Your Ref: OWPC6065
Our Ref: AW/62/15/HH 02-03-2015
Please ask for:
Mrs J Chapman

Conservatory & double entrance doors. Amendment to previous permission
AW/201/14/HH. This application affects the character & appearance of Craigweil House
Aldwick Conservation area
53 Kingsway Aldwick

Thank you for your internet representation made on 18th June 2015 which has been recorded
as '**an objection**' with the comments as follows:

Title
EXISTING &
PROPOSED
ELEVATIONS
Project
SPEEDWELL
KINGSWAY
CRAIGWELL EST.

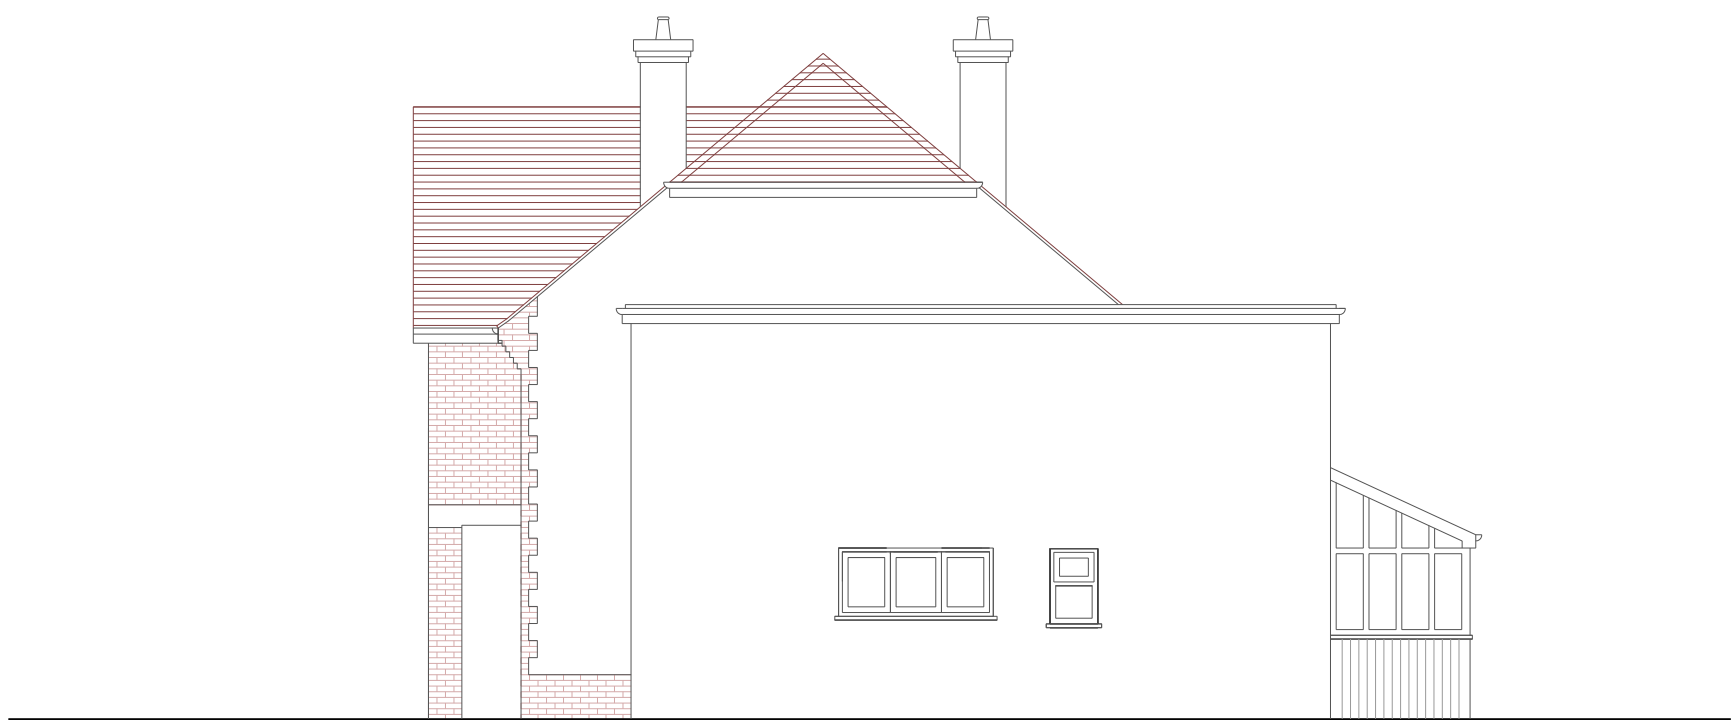
*This was not on the original approved development and brings the building even closer to
us. Also the pitch of the glass roof is too high making it too visible to neighbours*
